28 November 2016

BANGO WIND FARM

Sharon Langman
DIRECTOR PLANNING

Figure 3.2: Transportation Routes to Wind Farm Site Access Points

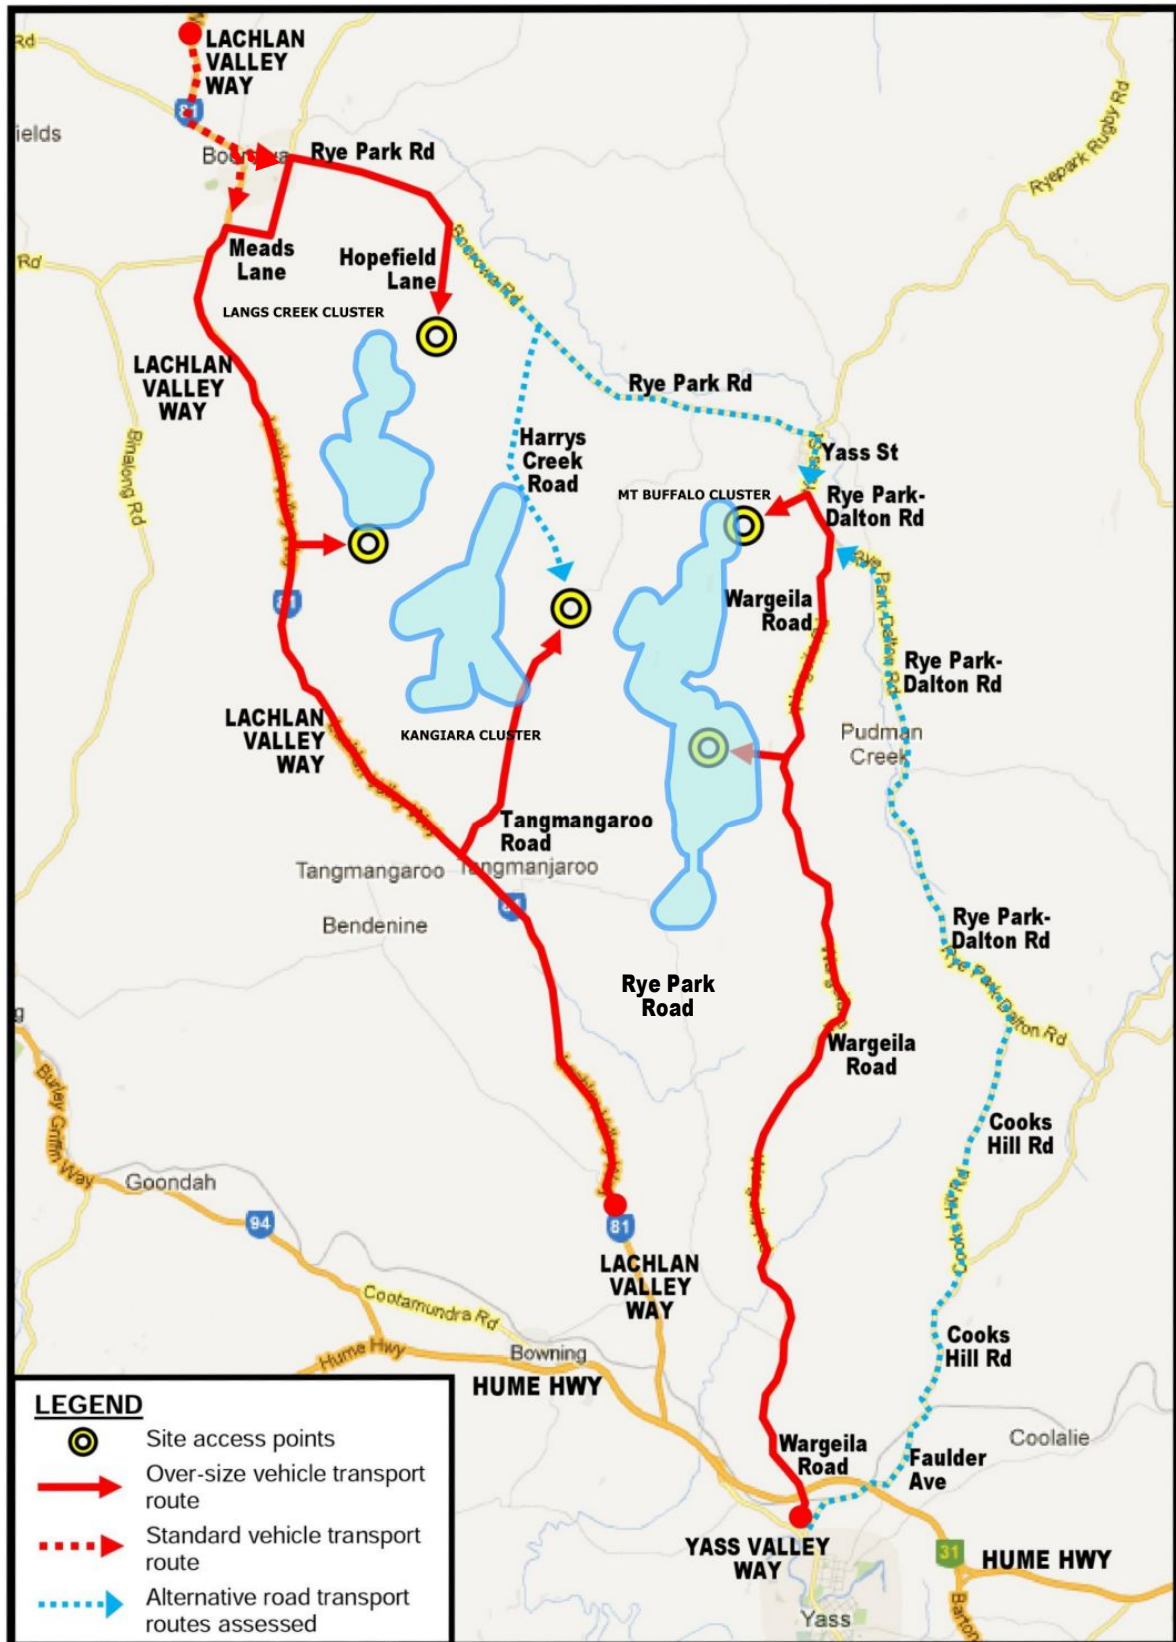
Council owned roads that have been identified for use as transport routes on the project are low standard, low volume roads which are constructed to cater for predominantly light vehicles. The structural capacity of the road pavement on these roads is not capable of withstanding large numbers of heavy vehicles, and many sections of road will deteriorate rapidly if used in their current condition. These sections need to be upgraded prior to construction of the wind farm to ensure the ongoing safety of road users. A “damage and fix” approach will not provide a satisfactory outcome for a large proportion of the road network.

It is noted that proposed sources for raw materials such as gravel for use on internal and external road networks, have not yet been defined. This is of concern to Council as it is considered likely that local sources close to the project site will be utilised rather than purchasing gravels from existing commercial quarries which are some distance away. The transport of gravel and other raw materials could potentially utilise routes not identified in the Traffic and Transport Assessment and would have a significant detrimental impact on road safety and the local road network in general.

To ensure Council is able to reach agreement with the proponents, and noting that actual transport routes are not yet finalised, suitable conditions of consent should be included to ensure Council’s agreement with the proposed road standards and extent of road upgrades, and to obtain Council’s approval of the Traffic Management Plan for the project prior to any works commencing. The consent should also provide sufficient flexibility to allow for further road upgrades if necessary once final material sources and transport routes are confirmed.
